**Dogger Bank South Offshore
Wind Farms**

**Marine Management Organisation – Statement of
Common Ground Update**

Document Date: December 2025

Document Reference: 22.6

Figure: 2-2	Drawing No: PB2340-MAR-OF-ZZ-DR-Z-0013	
Co-ordinate system: WGS 1984 UTM Zone 31N	Page Size: A3	Scale: 1:950,000
Project: Dogger Bank South Offshore Wind Farms	Report: Heat Mapping Report: Atlantic Herring and Sandeel

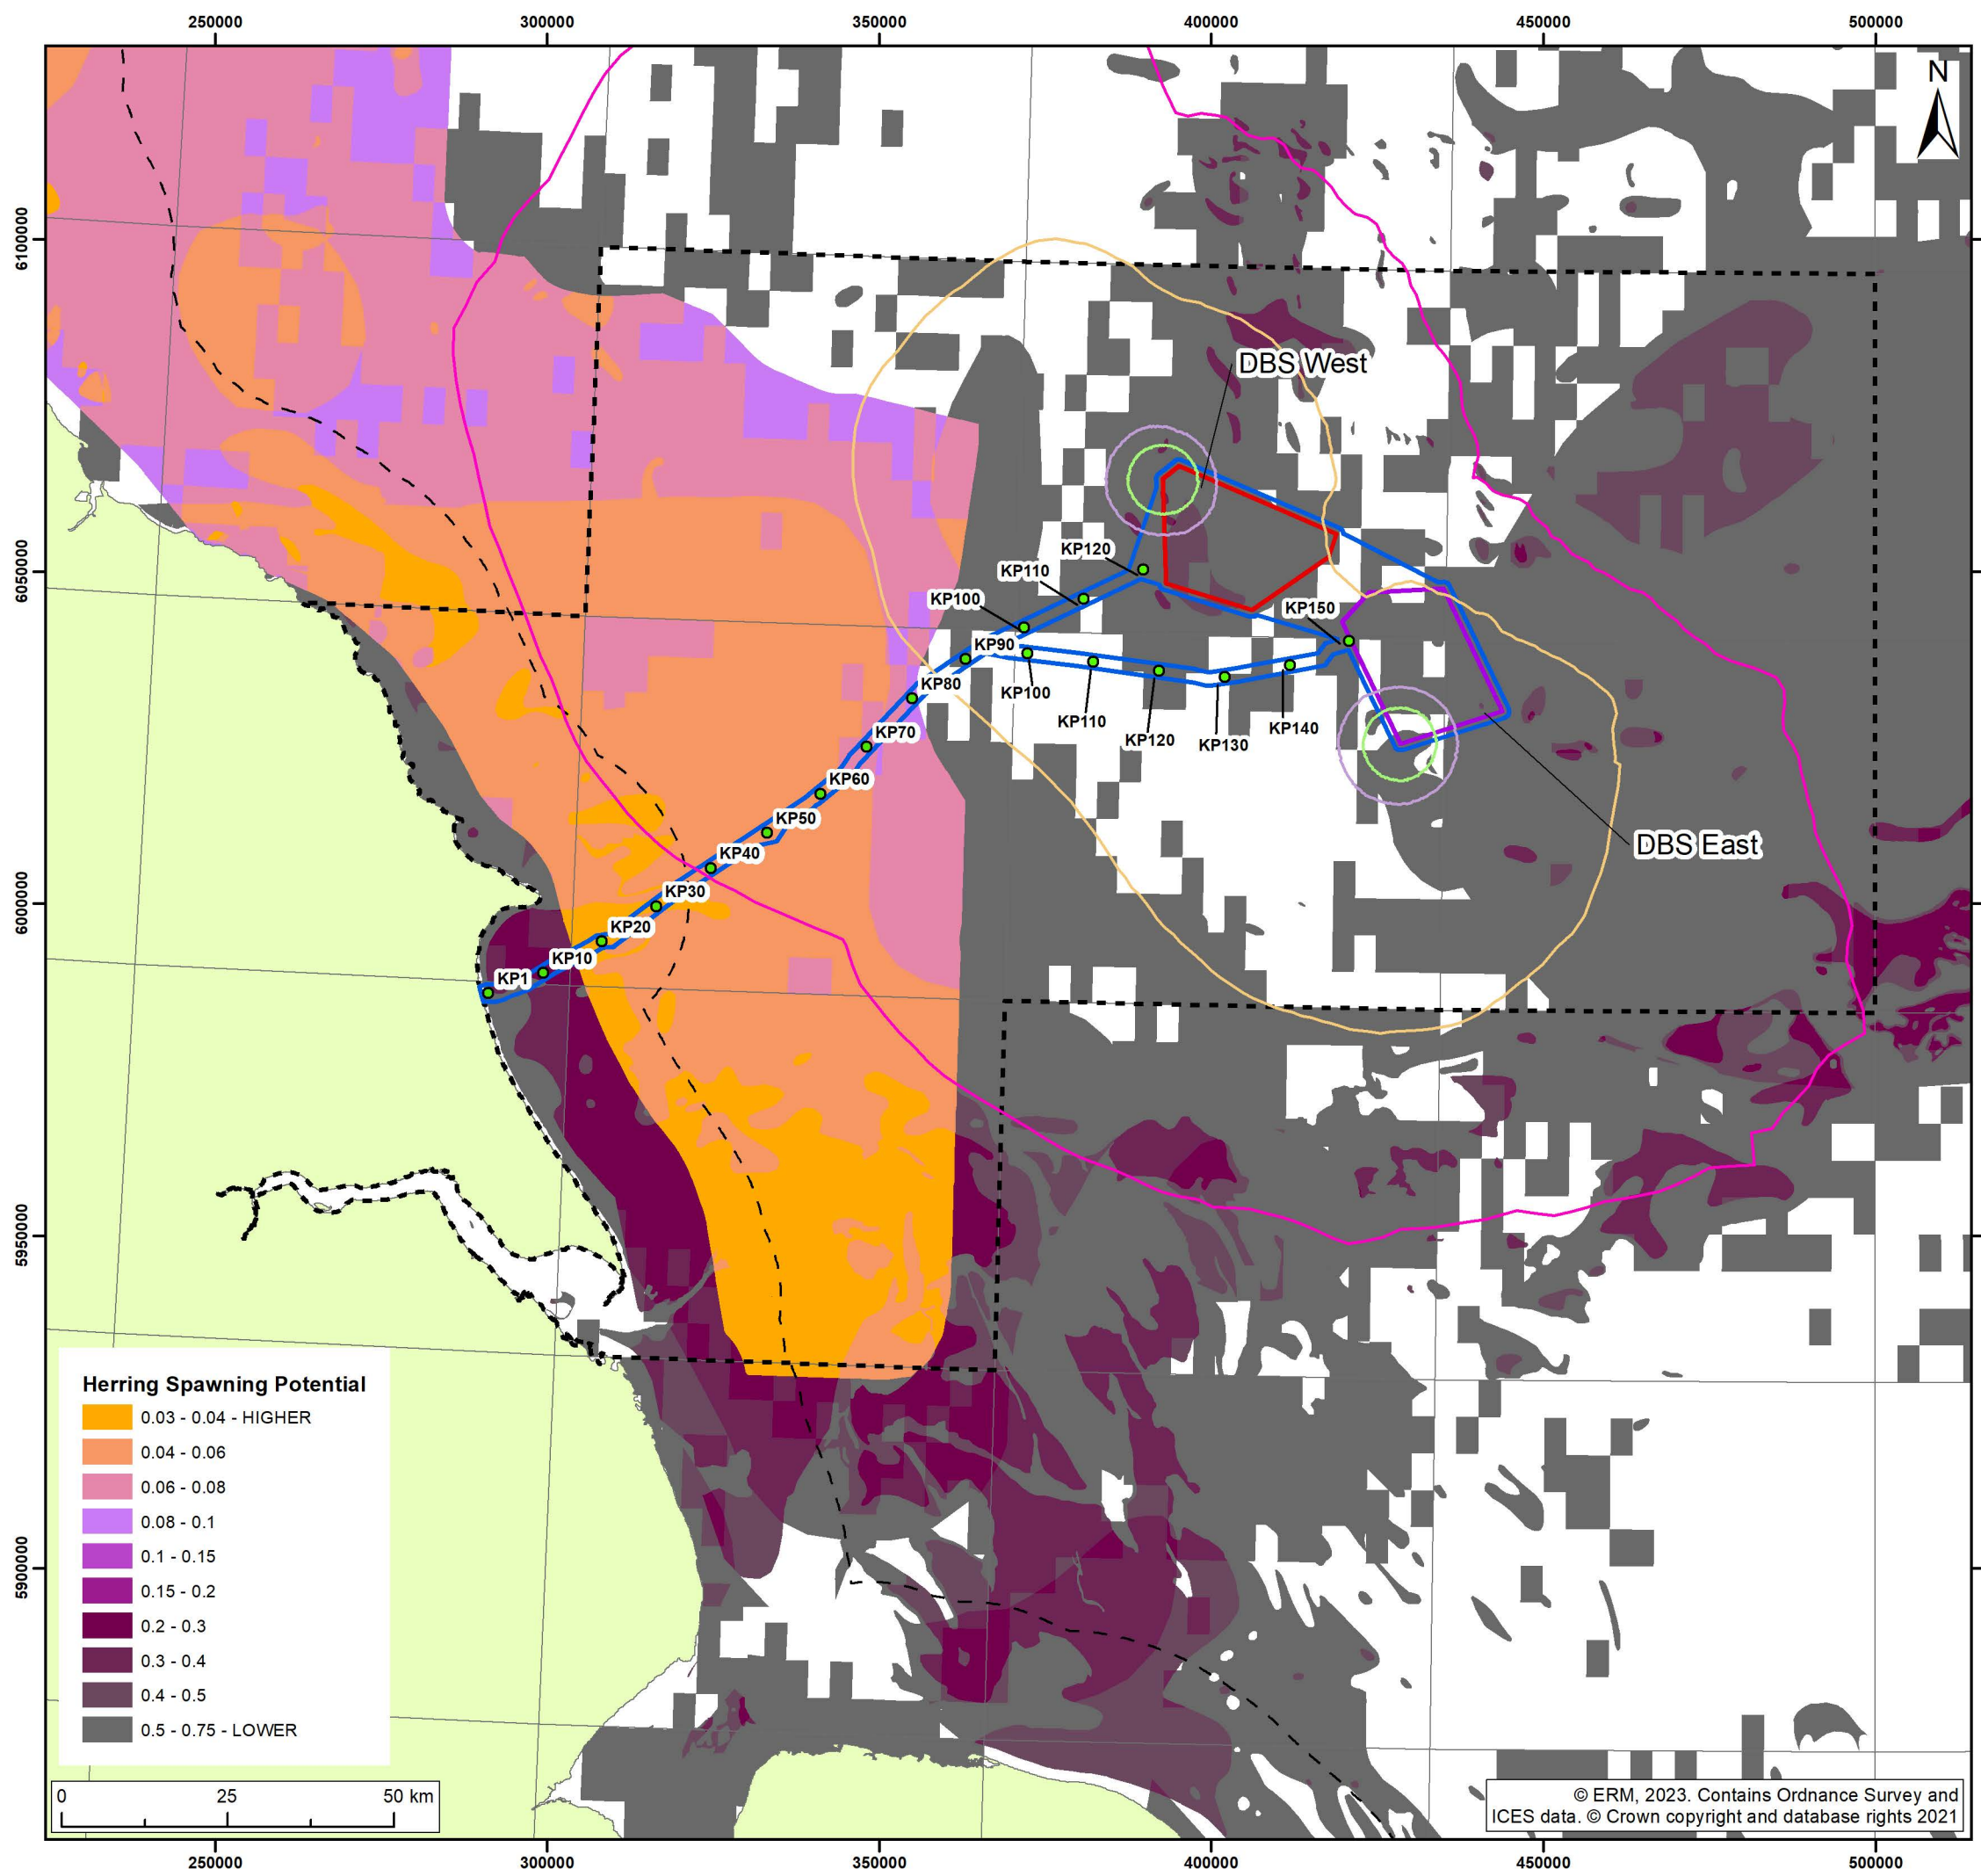
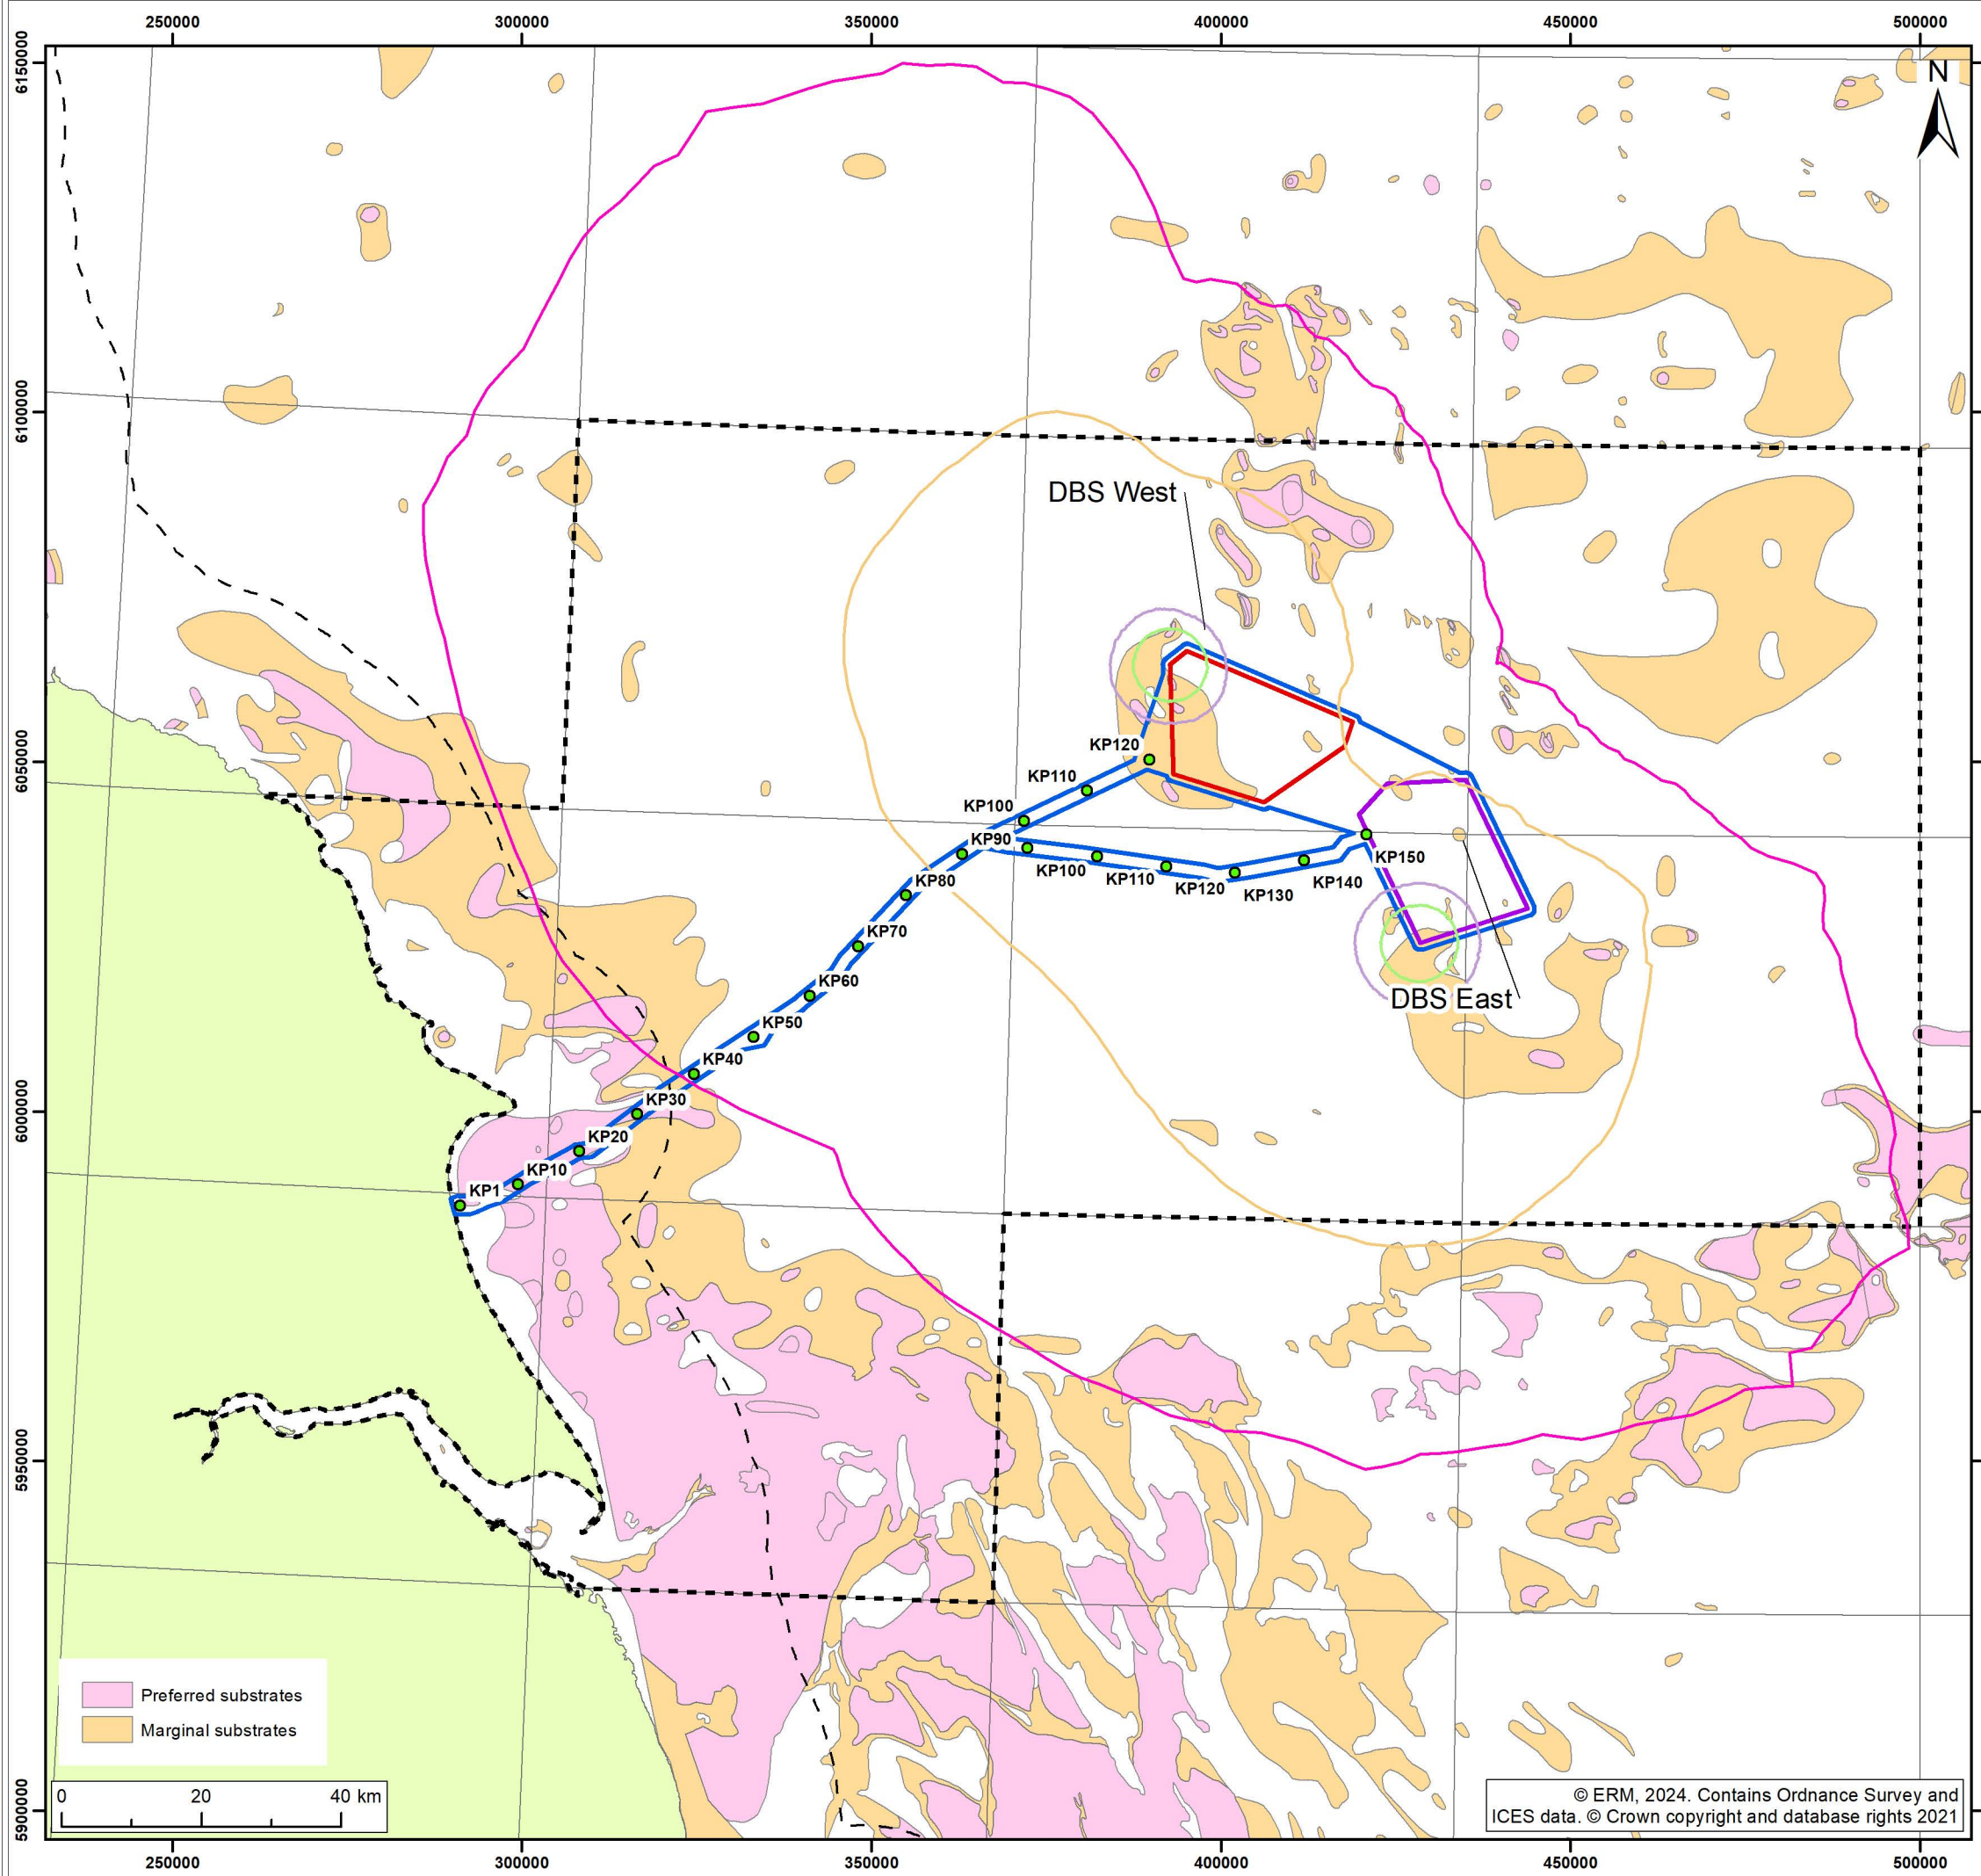
69	<p>The impact assessment methodologies used for the EIA, as presented in section 10.4.3 of Chapter 10 Fish and Shellfish Ecology [APP-091], provide an appropriate approach to assessing potential impacts of the Projects.</p>	<p>1. The MMO requests that the Applicants revises their potential herring spawning habitat and potential sandeel habitat 'heat' maps preferably using the updated version of the MarineSpace methodologies.</p>

SoCG ID	The Applicants' Position	MMO's Position	Position Status
	<ol style="list-style-type: none"> The heat mapping methodology has been updated using the latest MarineSpace guidance within the Heat Mapping Report: Atlantic Herring and Sandeel [AS-105], submitted 28th November 2024. The Applicants acknowledged the MMO's position in The Applicant's Responses to Written Representations [REP2-057] (REP1-074:2.4) but would welcome any comments at the earliest opportunity. The Applicants provided a response in The Applicants' Responses to Deadline 2 Documents [REP3-028] (REP2-061:24). In addition, figures presenting the IHLS data were provided in Appendix A (Figures 2-1 to 2-4 and Figures 3-1 to 3-4) of The Applicants' Responses to Deadline 2 Documents [REP3-028]. The Applicants acknowledge the MMO's comment. During a meeting with the MMO and Cefas on the 15th May 2025, it was confirmed that the additional figures supplied in Appendix A (Figures 2-1 to 2-4 and Figures 3-1 to 3-4) of The Applicants' Responses to Deadline 2 Documents [REP3-028] were sufficient. The Applicants consider this matter closed out. 	<ol style="list-style-type: none"> The MMO stated in the Deadline 1 submission [REP1-074] that they would provide a response to comments relating to Fisheries and Shellfish at Deadline 2 or 3. The MMO provided comments on Fish and Shellfish at Deadline 2 [REP2-061] but queried that the Applicants are missing some key data in the Heat Mapping Report Atlantic Herring and Sandeel [AS-105]. The MMO is content with the heat maps provided.
